App No: BE/38/19/PL

Address: Adjoining site at 10 Acre Field west of Saltbox Rowan Way Bognor Regis

Proposal: Creation of temporary soil storage bund associated with development of adjoining site at Saltbox

TOP SOIL RELOCATION
SITE PLAN
1744-TS-P02-A
1:1250 @ A3
12.02.19
DRAWN BY

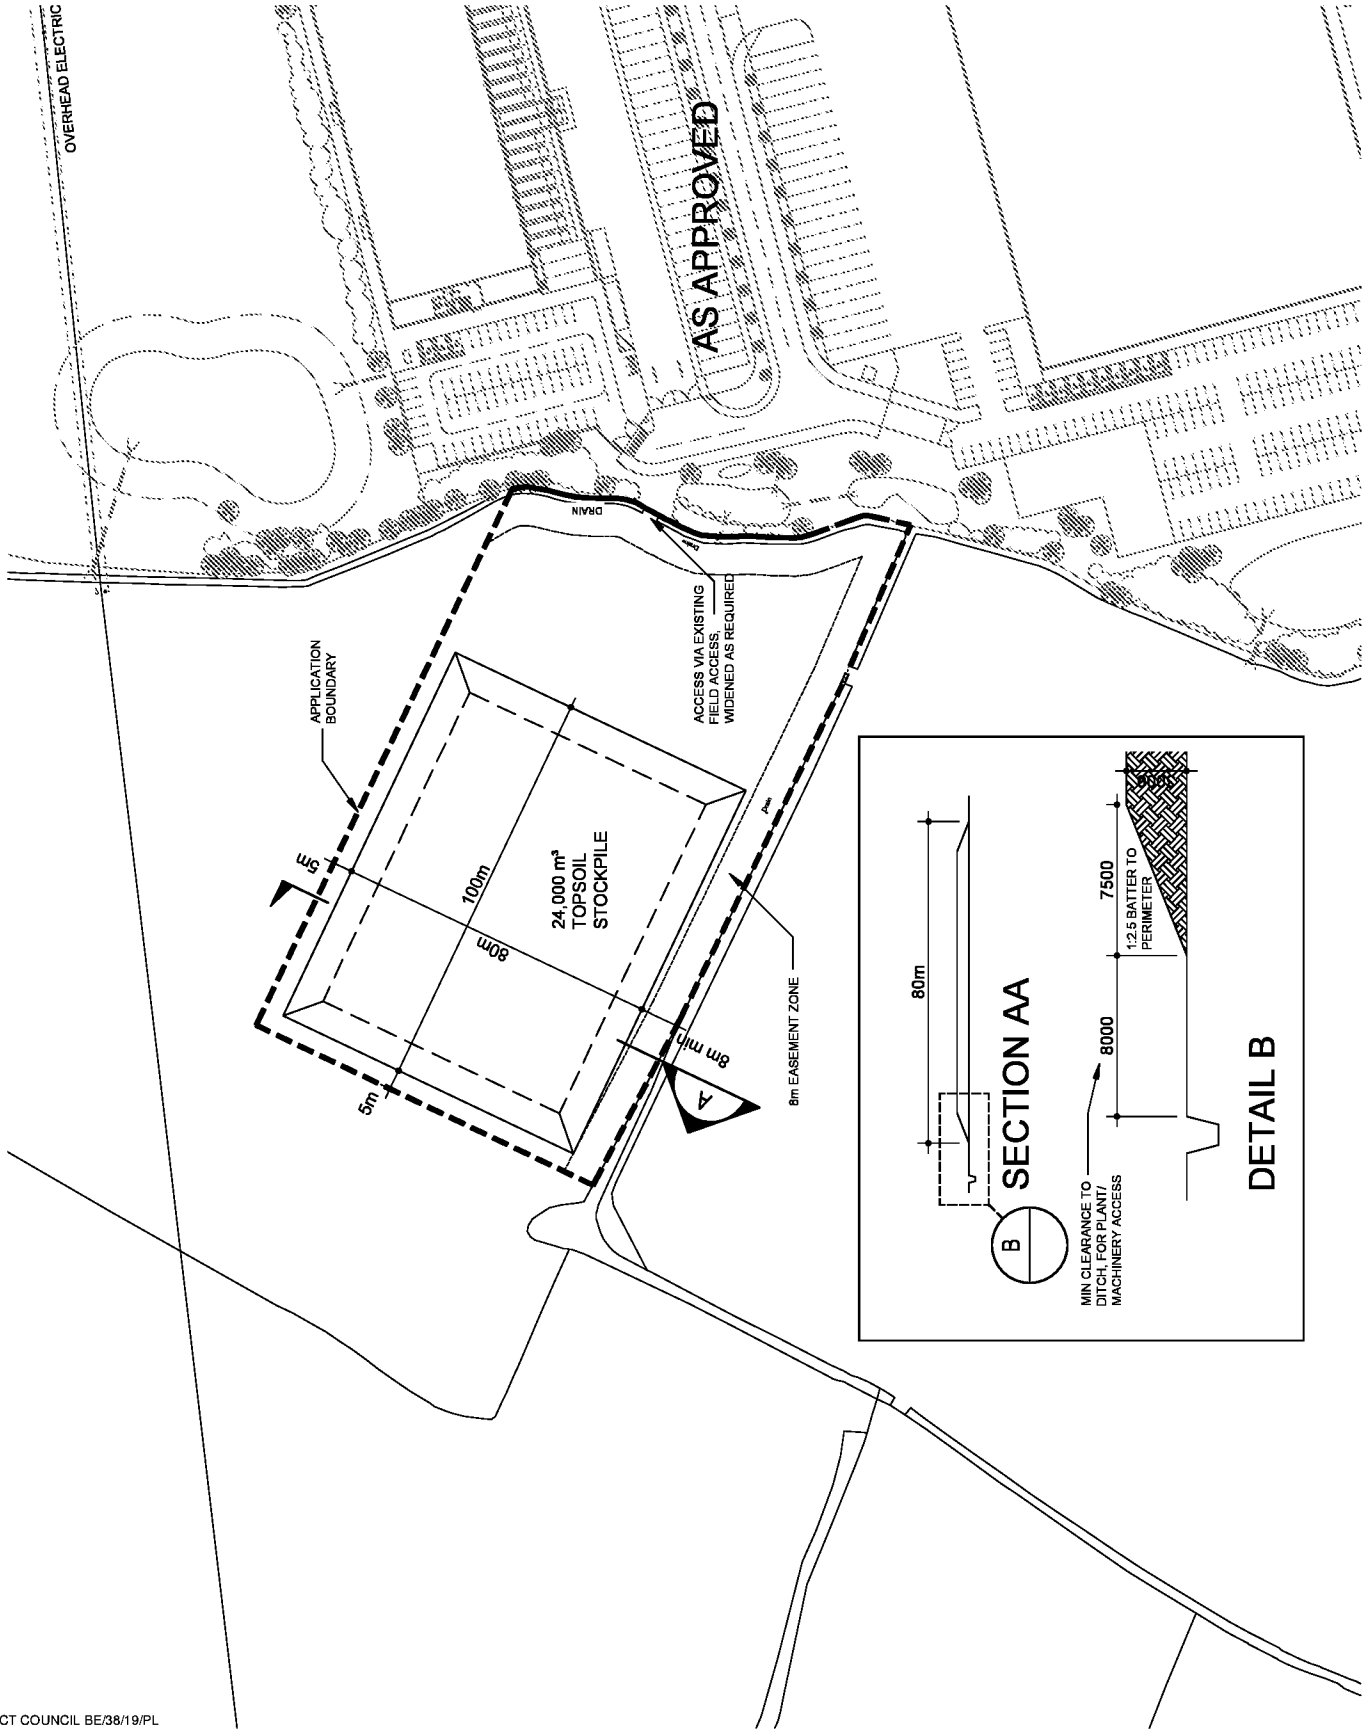
As detailed within the ecological report an 8m easement / buffer area will need to be included between the stockpile and the southern and eastern field boundaries.

Fencing should be used to protect the boundary features to ensure no works encroach on these areas and should tie in with the construction fencing required for the previous permission.

Works should proceed in a directional manner so the southern extent of the stockpile is created first and retained the longest to provide an additional buffer and screening.
